Appendix 1

Submission SSD 9483 Chatswood High school redevelopment

Transport Impact Assessment Appendix 21

Figure 2.5: Centennial Avenue Site Vehicle and Pedestrian Access - Existing

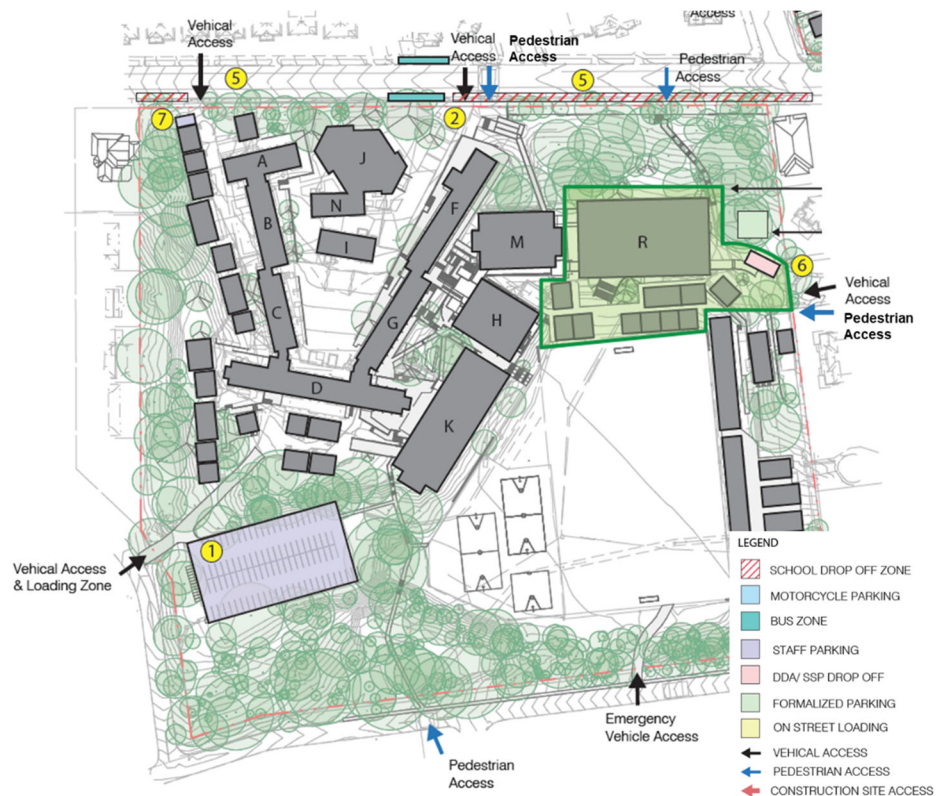
The report's analysis of parking is unbelievable – literally. Figures 2.5 and 2.10 in the Traffic Impact Assessment that purport to show the existing vehicle and pedestrian access to the High School and adjacent parking capacity is wrong.

The applicants should be required to submit a realistic traffic impact statement that accurately reflects the current and future situation and provides realistic remedies. That report should be made available to interested parties for comment prior to the project being considered for approval

Figure 33 Building T Floorplate (at Ground Level)

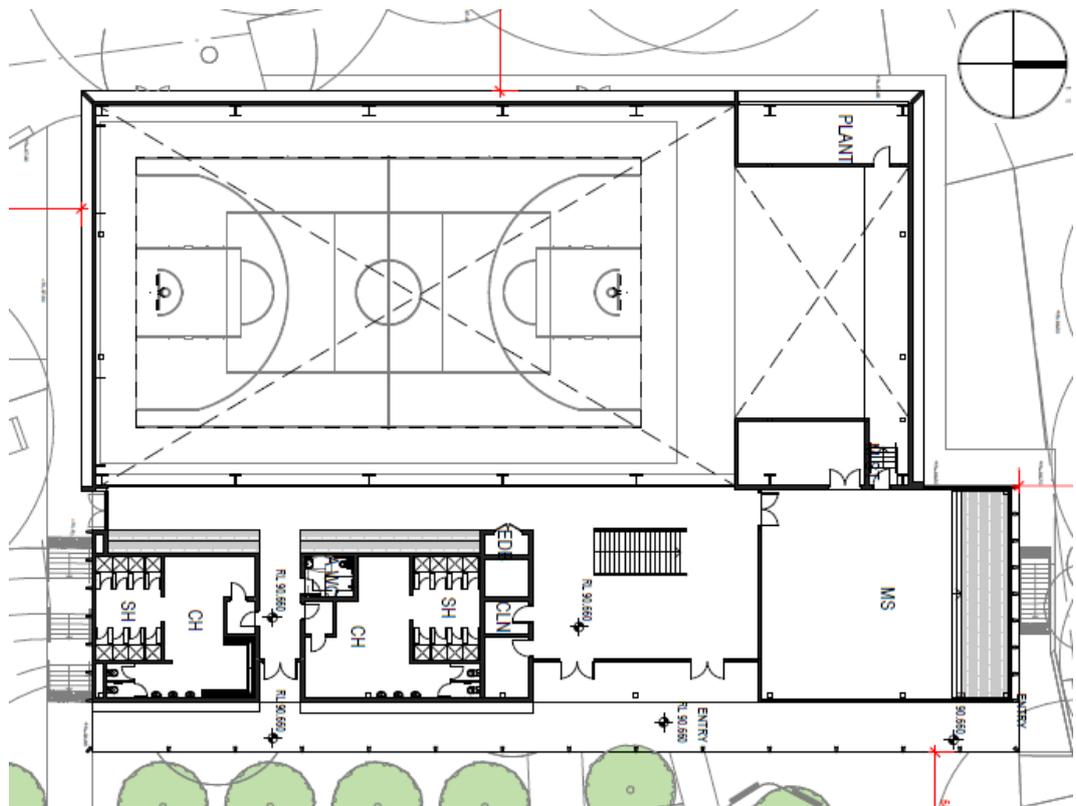
The plans for building T include a 'plant room' but there is no definition of what will go into that room, nor of how it is acoustically shielded. Nor does this feature in the Acoustic report. Dept. Edu have said it will be hot water only at opening, but that other machinery may be installed later.

The report speaks of a lift in Building T, yet none is shown in the plans. Dept. Edu. have since confirmed there will be a lift

The applicant should be required to submit details of what machinery will go into the plant room and how that will be acoustically shielded

The applicant should be required confirm how the acoustic impact of the lift will be mitigated and that the noise impact on neighbours will be within tolerance
